About the application

Application number: 2019/90397	
What is the application for?:	Erection of front and rear single storey extension and dormers to side
Address of the site or building:	2, Squirrel Hall Drive, Dewsbury, WF13 4AH
Postcode:	WF13 4AH

PROPOSED GROUND FLOOR PLAN

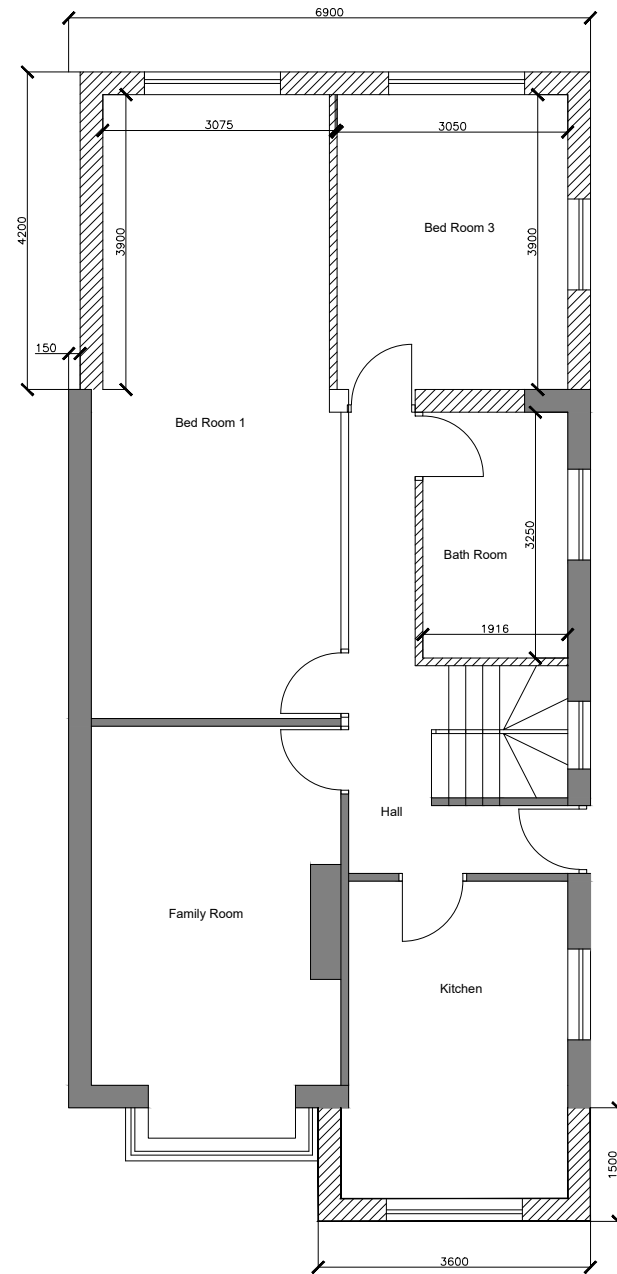
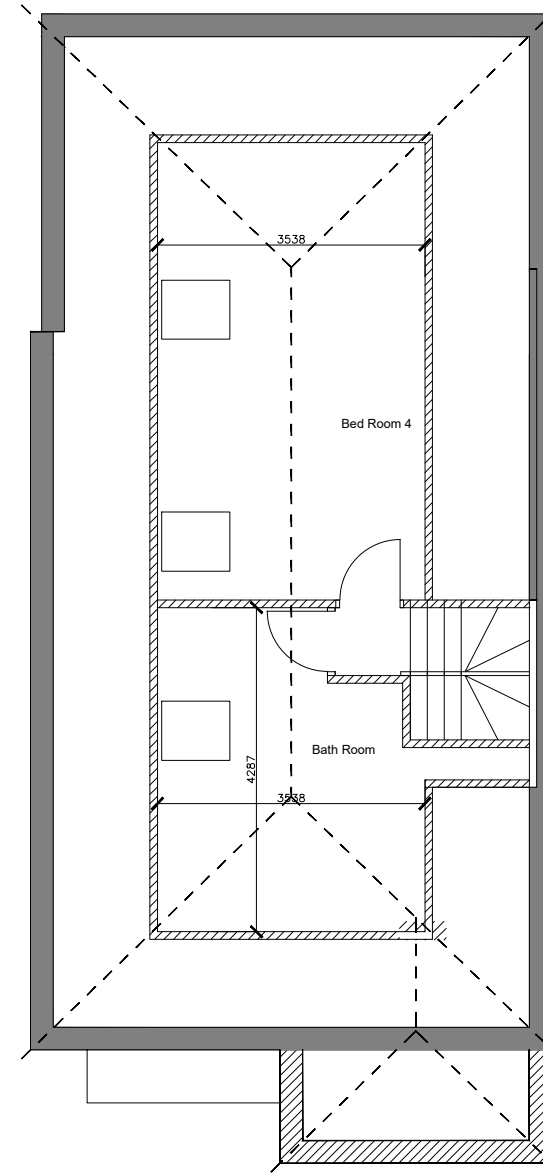
out as well as up the roof of the extension is likely to be very near the hedge, (if the hedge is allowed to grow without trimming as it presently is it will most certainly meet the roof).

This will reduce the amenity of the adjacent property by blocking light from windows in the rear and side of the property and through the massing/bulking effect it will cause.

The proposed dormers are again of a scale that is far too large and can not be found within the wider streetscene. They could not fit within the original roof area and have front and cheek walls that are too large causing the dormers to become dominant over the roof. The massing and bulking effect of such large dormers (particularly on a property in such a prominent location along with being located on a side elevation as opposed to the front and/or rear elevation which is the norm in the area) will have a large negative effect on both the host property and the wider streetscene). The original hipped roof does not lend itself to dormers of such a scale as it can not accommodate them without losing its form
